Substantive response of Blaby District Council’s Environmental Services Department

Application Details: 23/1047/DOC Discharge of Condition 13 (Construction Method Statement) attached to appeal decision (APP/T2405/W/23/3318532) pursuant to 22/0464/FUL	Site Address: 43 New Street Blaby
Planning Officer: Charles Ebden	Environmental Services Officer: David Gould
Date received: 13.12.2023	Date of submission of response: 04.01.24

43 New Street, Blaby (22/0464/FUL)

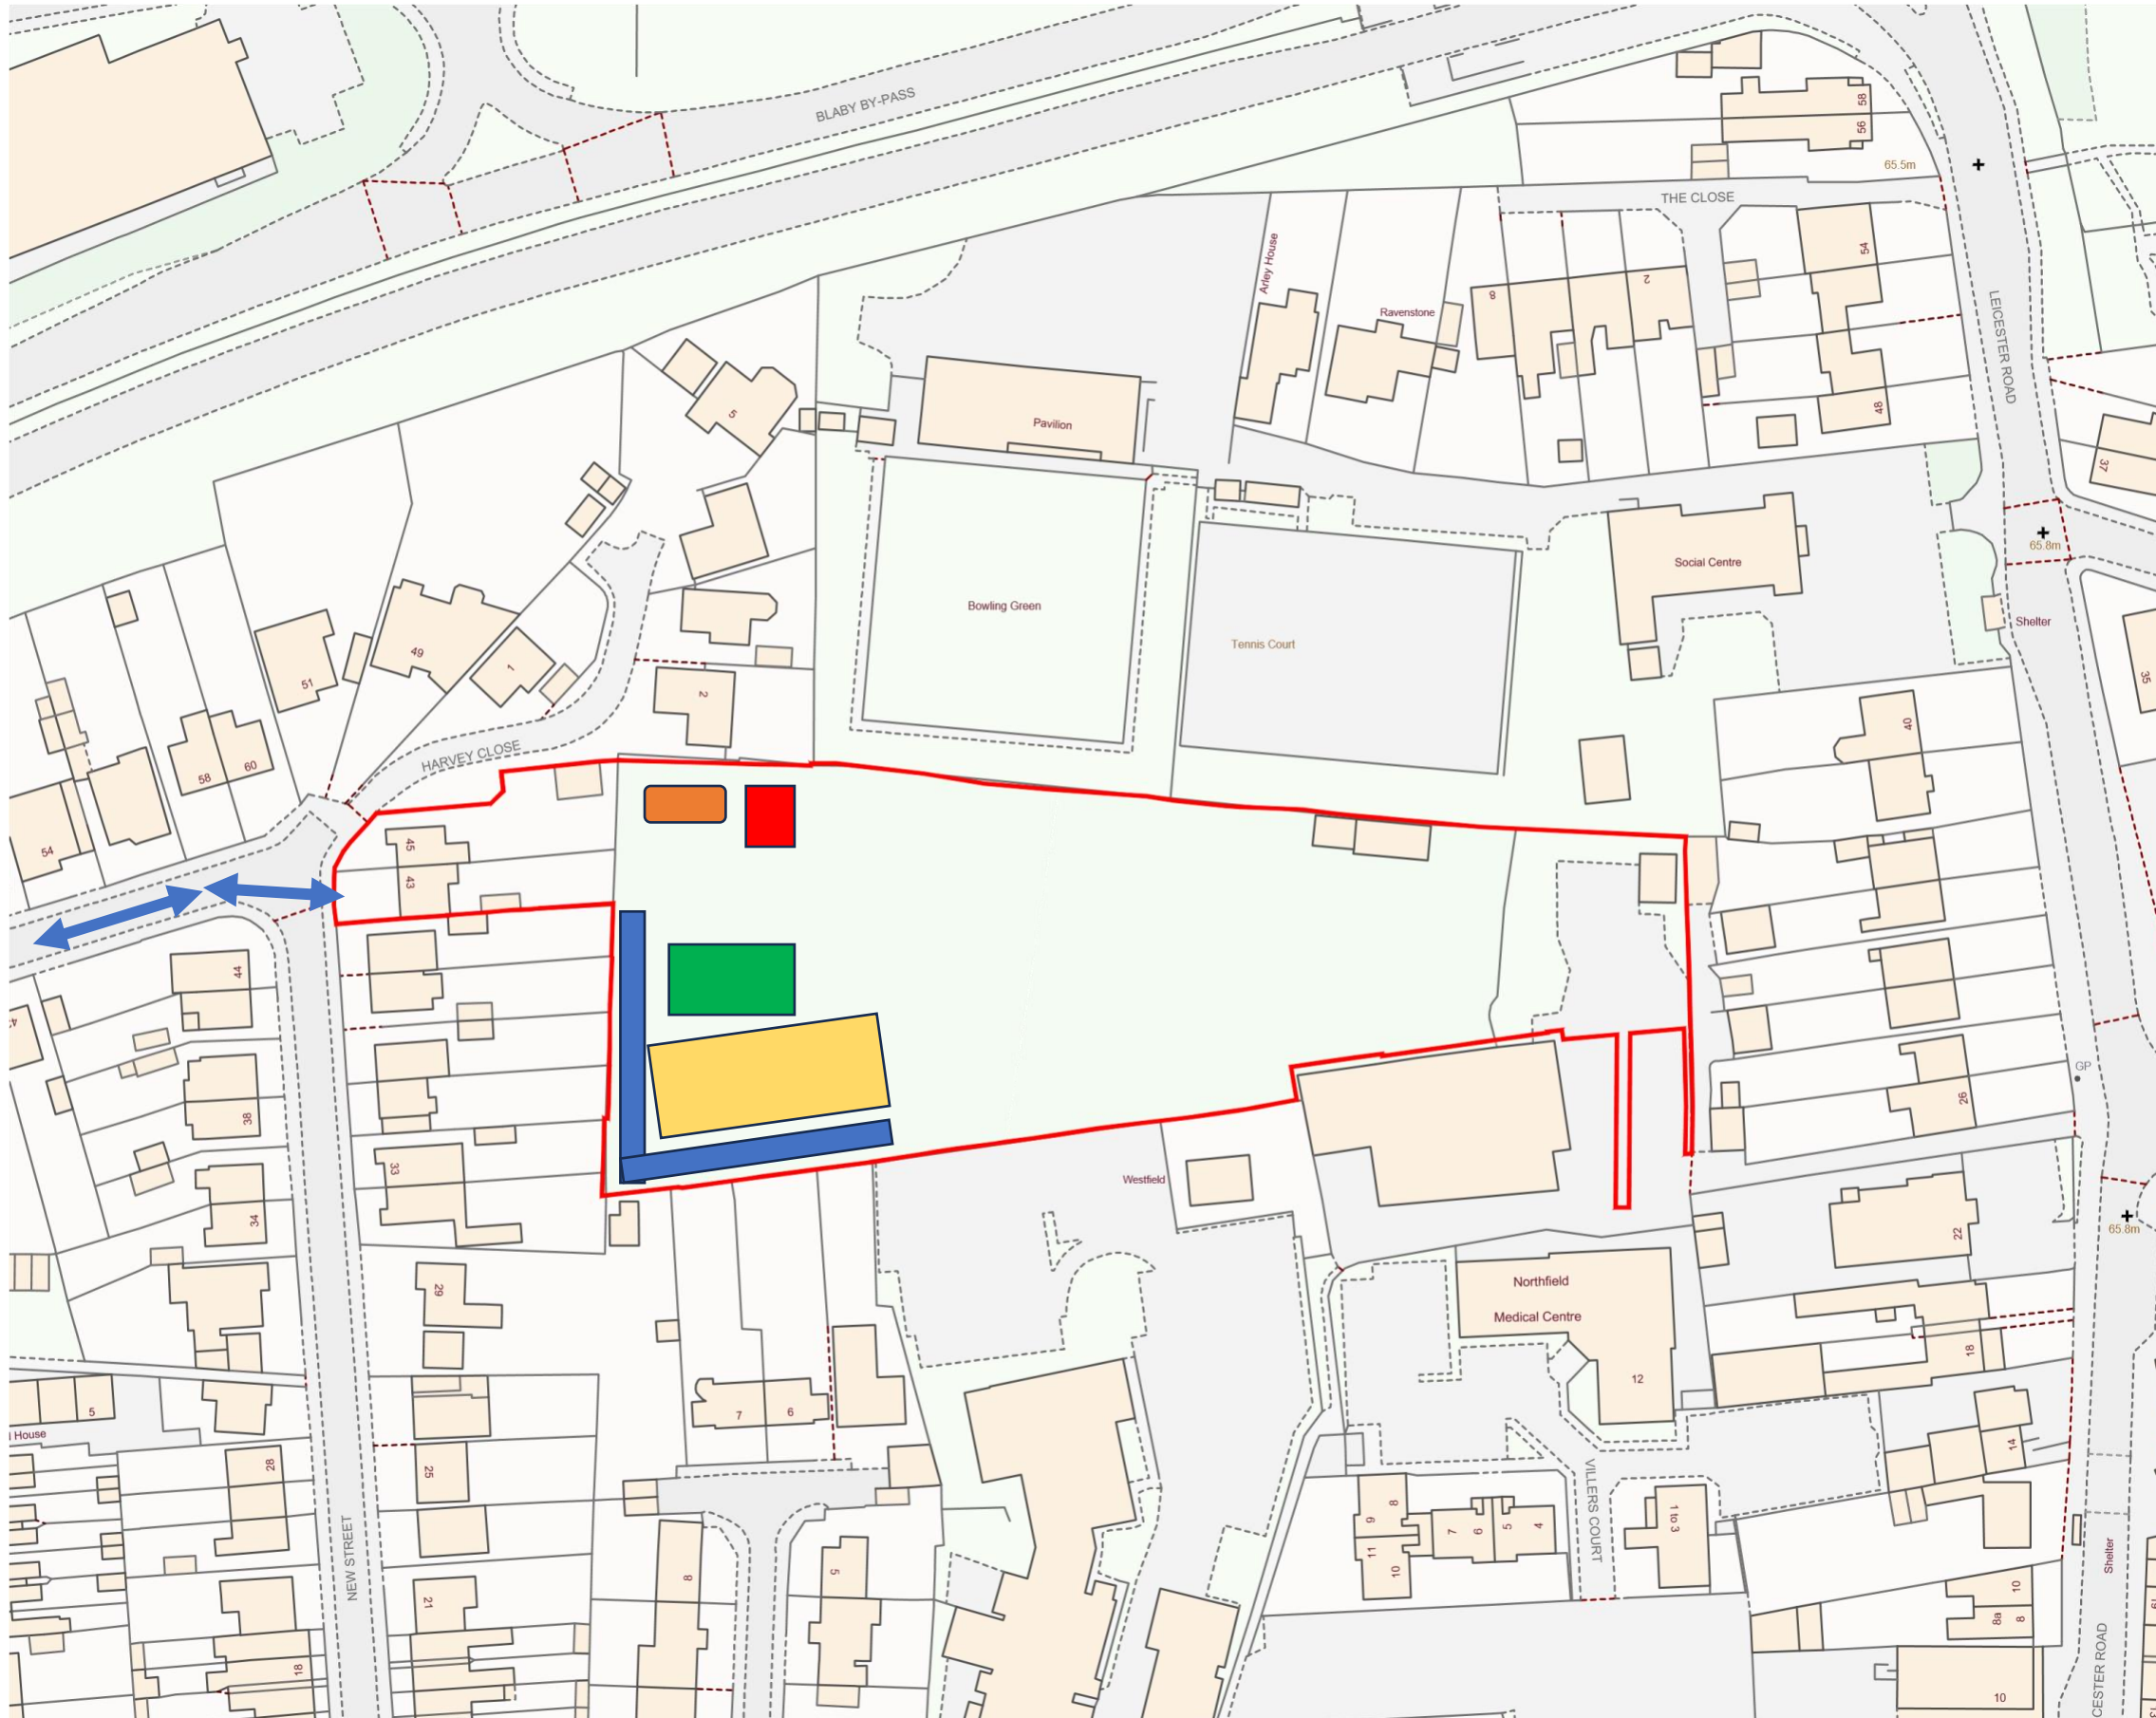
Some detail is provided regarding noise and vibration control, referring to a relevant British Standard. The document states that a noise bund is to be formed behind the houses on New Street to provide mitigation. The approximate location of such a bund is indicated on the attached site plan. However no bund is shown behind 45 New Street, nor the properties on Harvey Close. Further details of the bund are needed (e.g. height, material to be used, scheduling of provision). The bunding should also be provided behind the other addresses mentioned.

The document states that lighting on the site would be powered using a generator if mains power is not available. Proposed location(s) for such a generator should be shown on the attached site plan, together with details of the likely plant and measures to ensure that noise and vibration does not cause off-site impacts.
